From: Carol Reynolds
Sent: 05 October 2016 11:54
To: Planning.Responses
Cc: Fiona Fitzgerald
Subject: Fwd: Planning Consultation on: LU/234/16/RES

Environmental Health Comment on that Report commissioned by Persimmon Homes on the Discharge of Condition 18, Fitzalan Link Road, North Littlehampton. Noise Assessment dated July 2016.

NOTIFICATION FROM ARUN DISTRICT COUNCIL
The Town & Country Planning Act 1990 (as amended)
Town & country Planning (Development Management Procedure)
Article 6
Approval of Reserved Matters Following Outline Approval
APPLICATION LU/234/16/RES
NO:

Description of Works: Application for reserved matters relating to the appearance, landscaping, layout and siting of the proposed works approved LU/63/11/. This application also includes a new access way

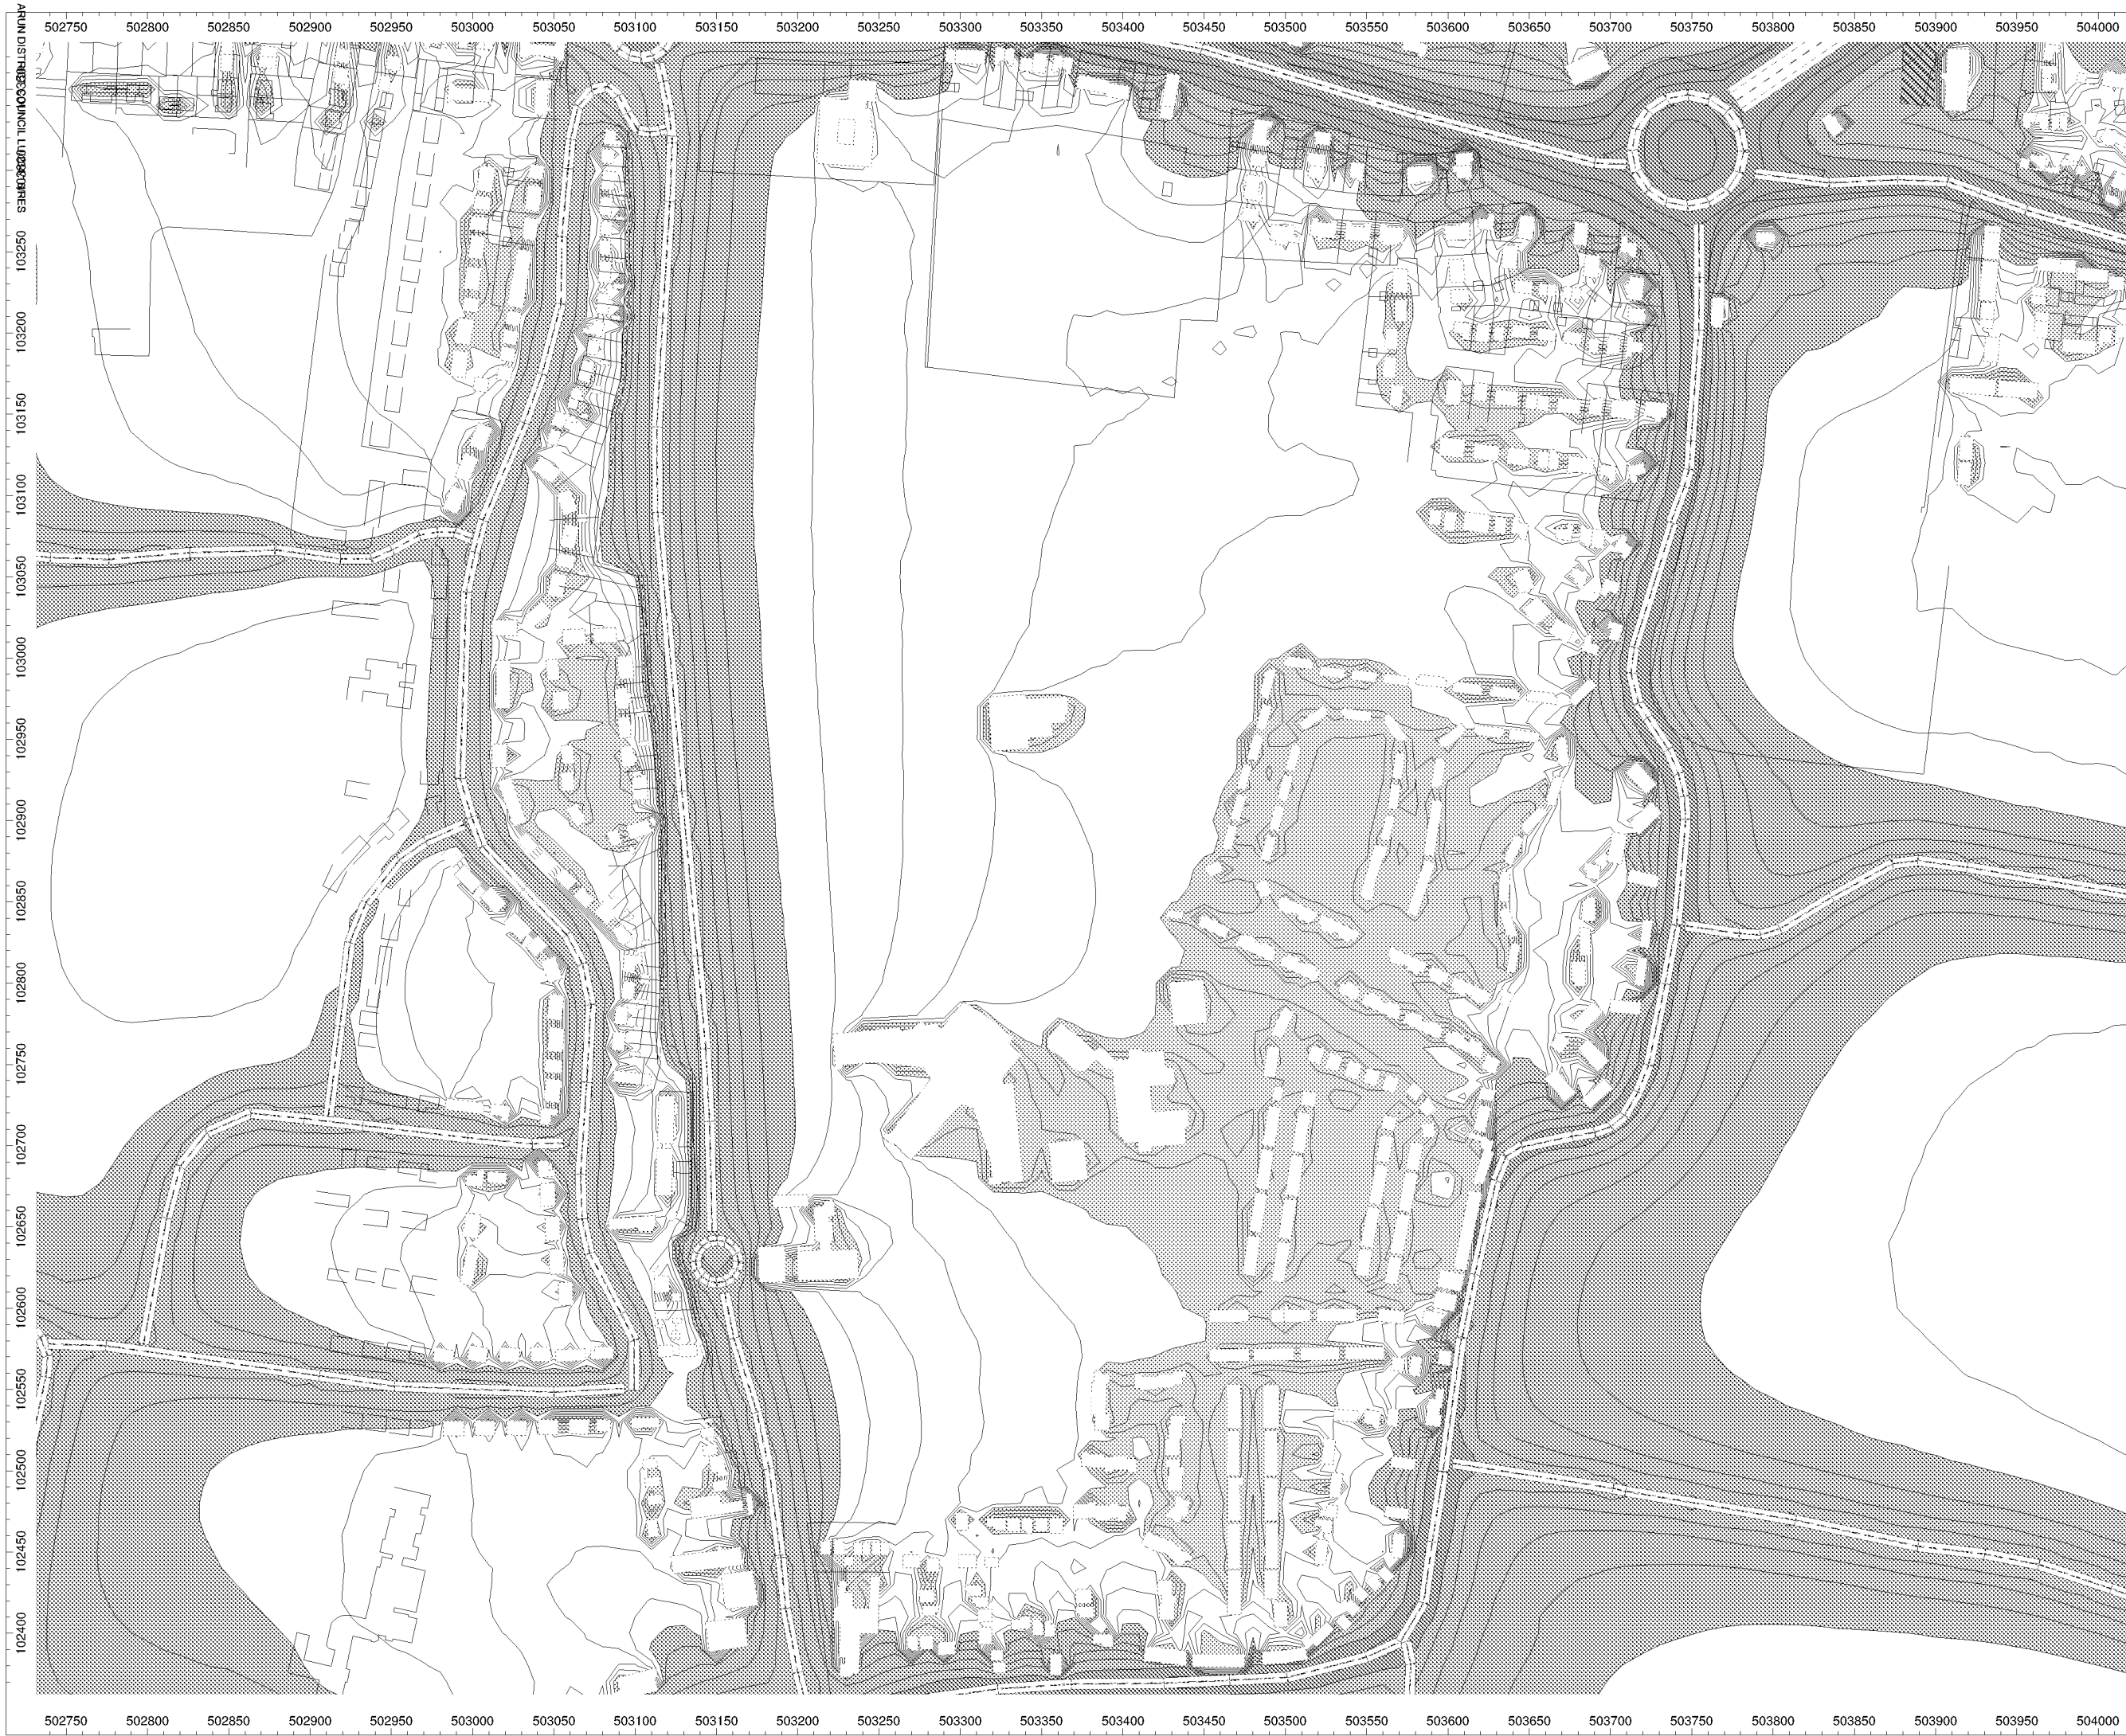
1. The proposed acoustic barrier will provide suitable noise mitigation for the majority of the noise sensitive receptors. However, the report indicates that some out door living areas will be exposed to high levels of ambient noise in excess of World Health Organisation Guidelines (ideally less than 50dB). Furthermore, that the noise level at some noise sensitive receptors will have significant adverse affect (definition Table 2.1 of the report). We would therefore request that the system of noise mitigation be reviewed to determine whether this situation can be further improved.
